**CITY OF PORTLAND, MAINE**  
**PLANNING BOARD**

August 17, 2012

Project Name: Cumberland County Civic Center                      Project ID: #2012-505  
Address: One Civic Center Square                                      CBL: 38-D-15 and 39-C-3  
Applicant: Cumberland County Recreation Center (Attn. Steven Crane)  
Planner: Richard Knowland, Senior Planner

SITE LAYOUT & MATERIALS PLAN

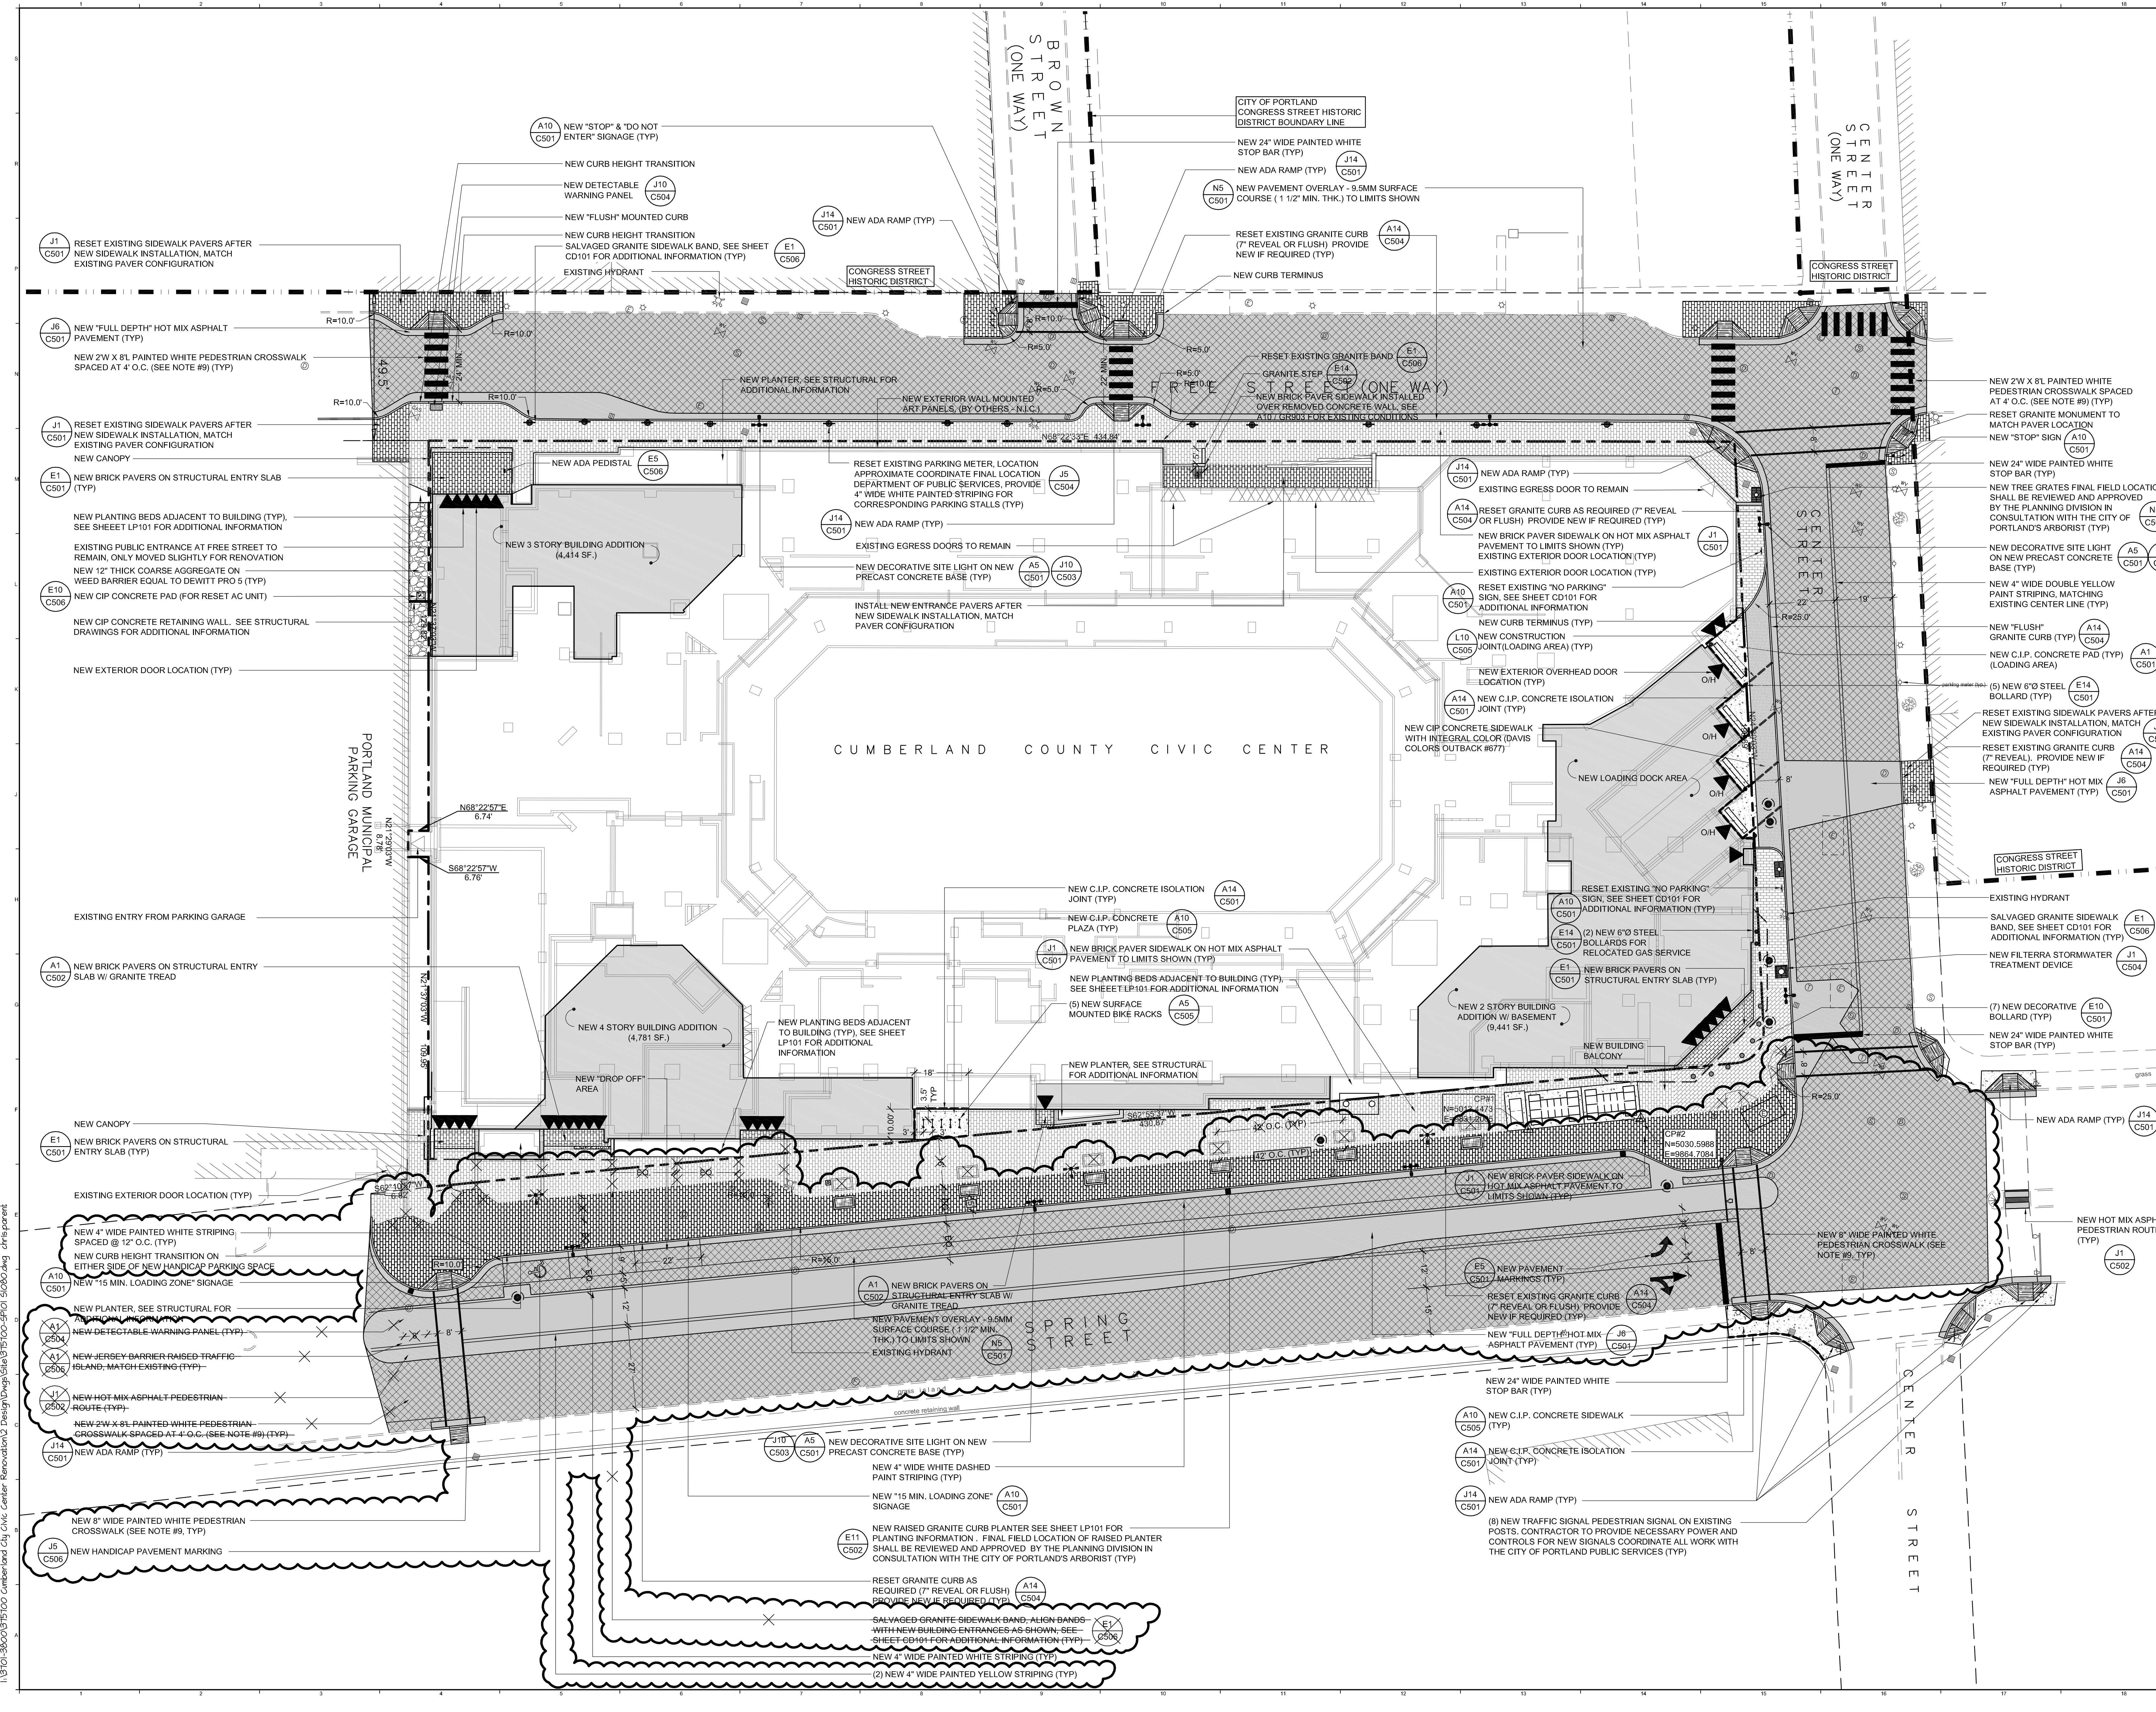
- The plans illustrate a painted crosswalk along Center Street in the vicinity of the Loading Dock area. I would suggest that a permanent material be considered.

- June 29, 2012: The plans call for a concrete surface that should help delineate the pedestrian walk area from the loading area. The applicant should confirm that this is the case.

- **Status – I find the details of the sidewalk in this area to be acceptable. I would note that the curb radii at the loading dock need to be flush with the sidewalk.**

PROJECT: CUMBERLAND COUNTY CIVIC CENTER RENOVATION
DELIVERY AT LOADING DOCK - RAMP
SHEET TITLE:

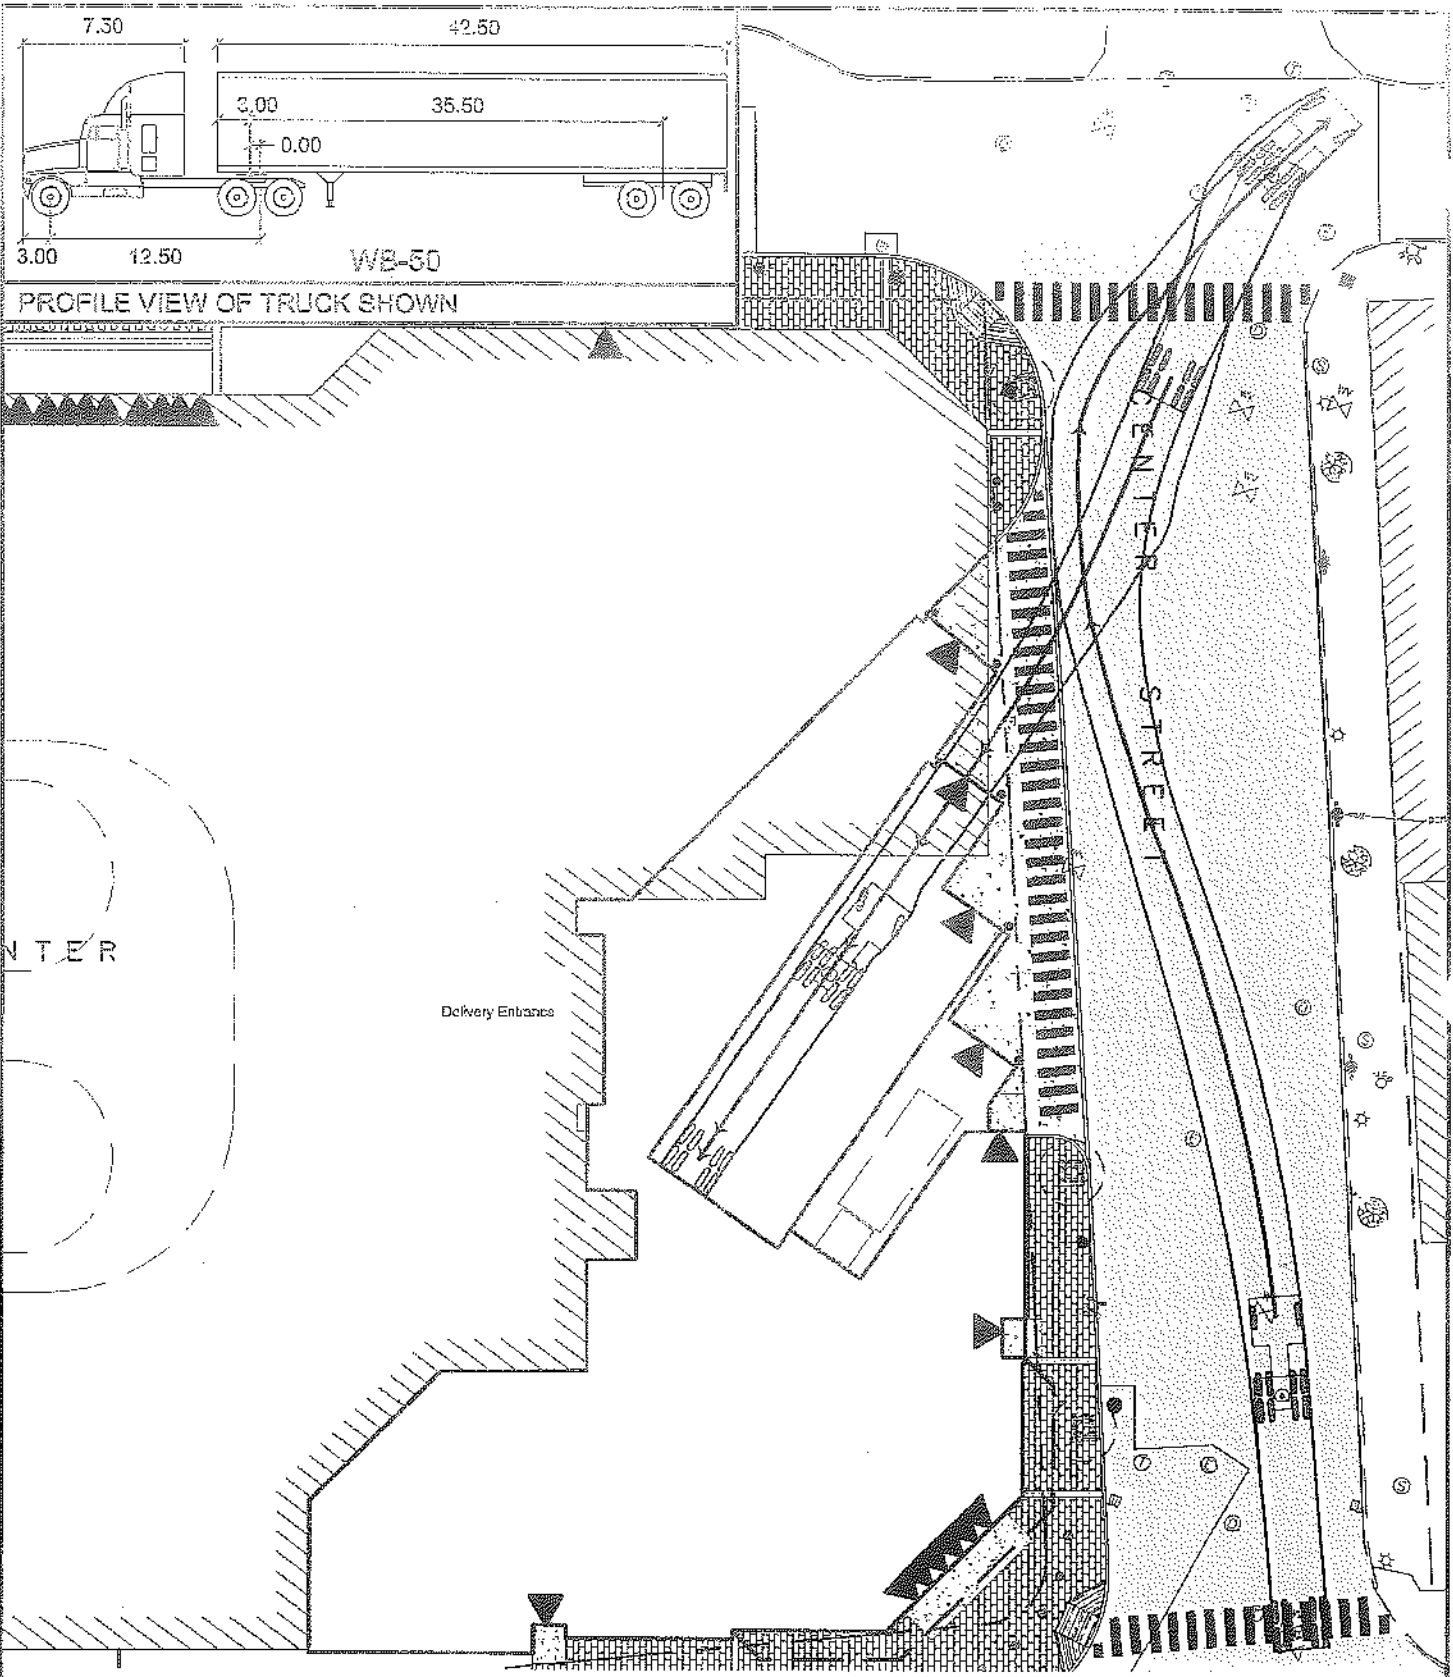
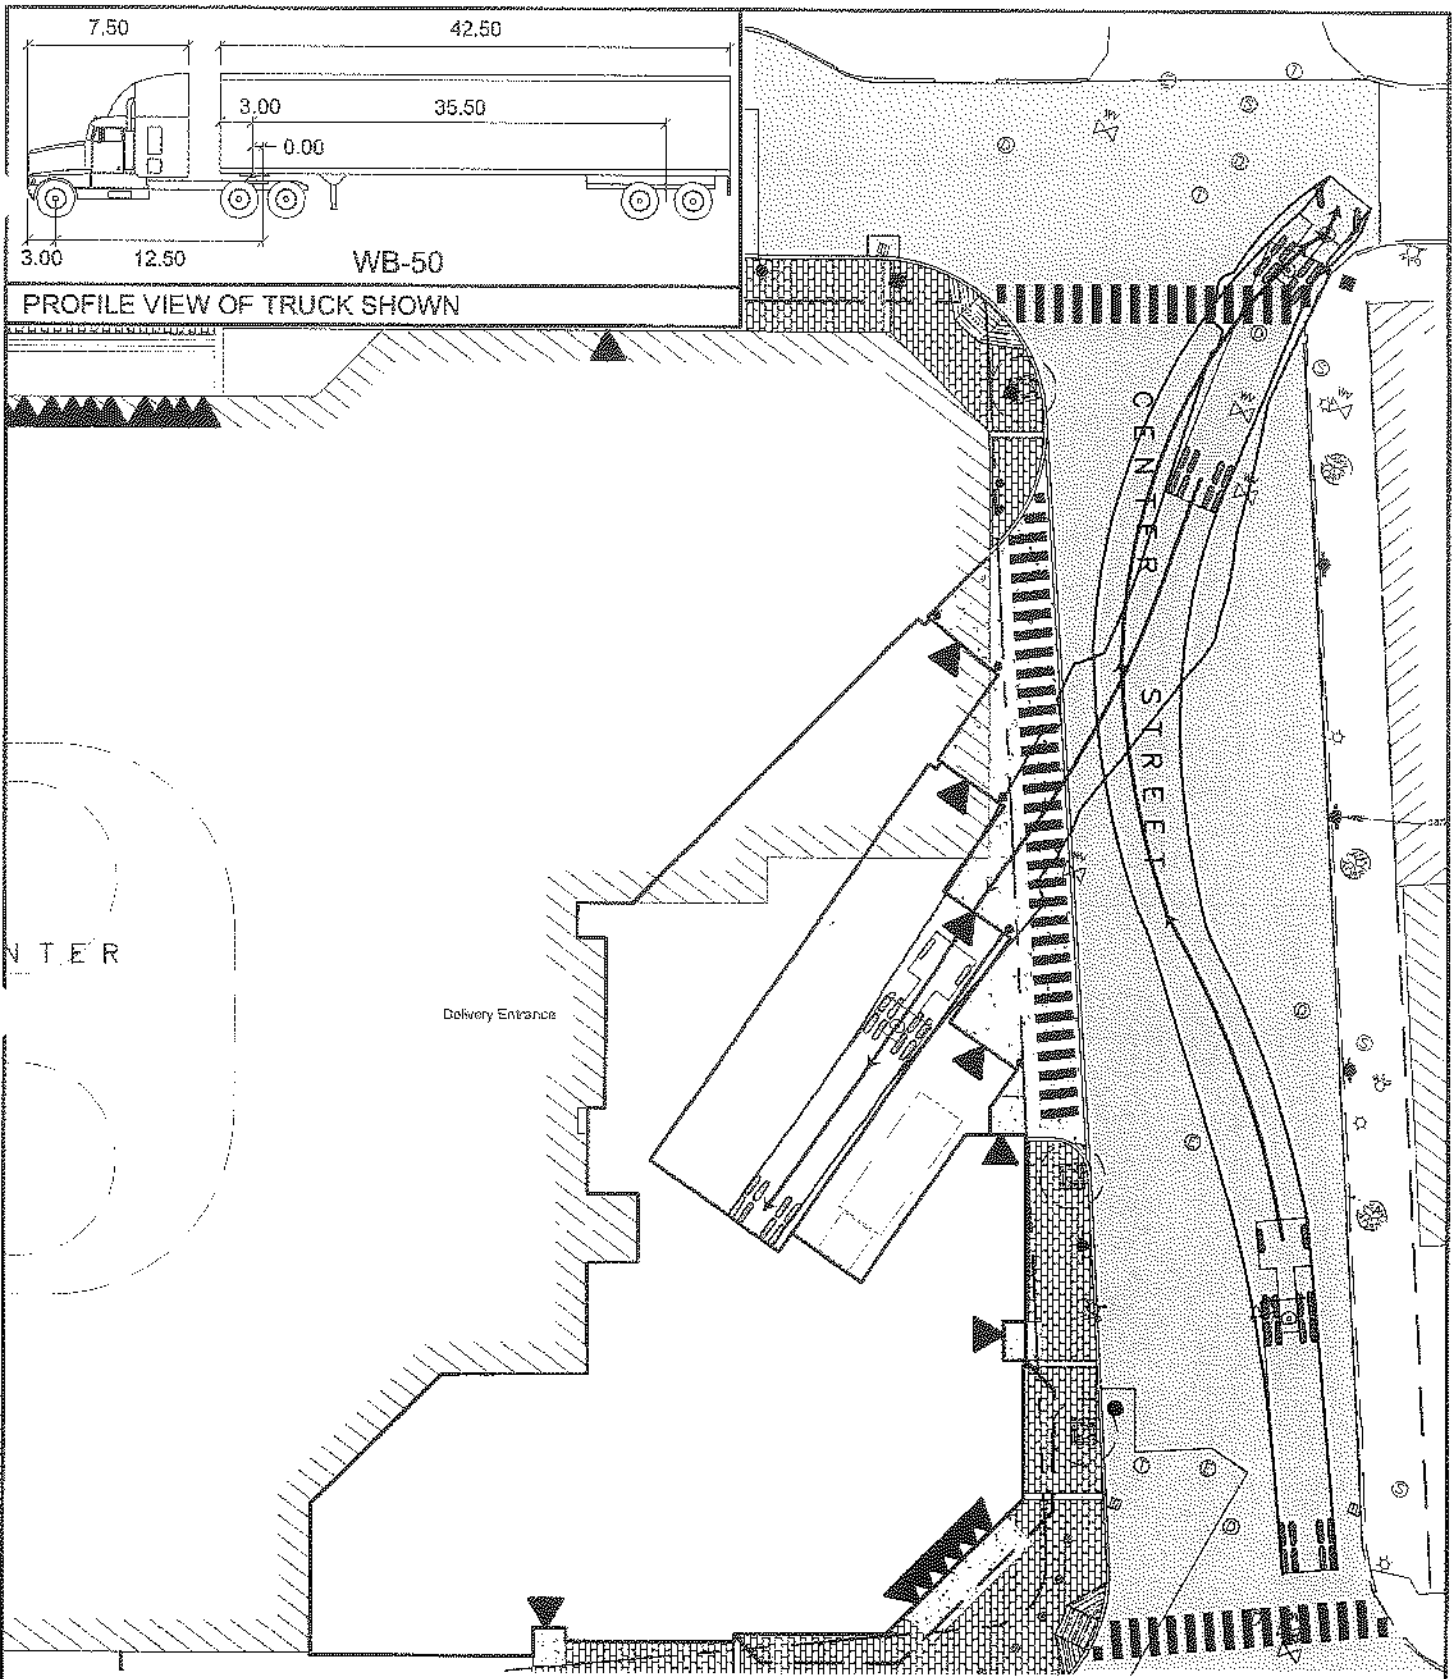
- June 29, 2012: This comment is no longer valid.
- **Status: No comment.**
- I have reviewed the turning template for truck maneuvers into the loading dock and find conditions to be acceptable for backing entry movements. The applicant should illustrate exiting truck maneuvers through the Center Street/Free Street intersection (the alignment of the loading dock will require movements towards Free Street only).

- June 29, 2012: Based upon my review of the video provided by the applicant, large trucks can make the turn from Center Street onto Free Street. This movement is very tight and requires flaggers and parking prohibitions on Center Street.
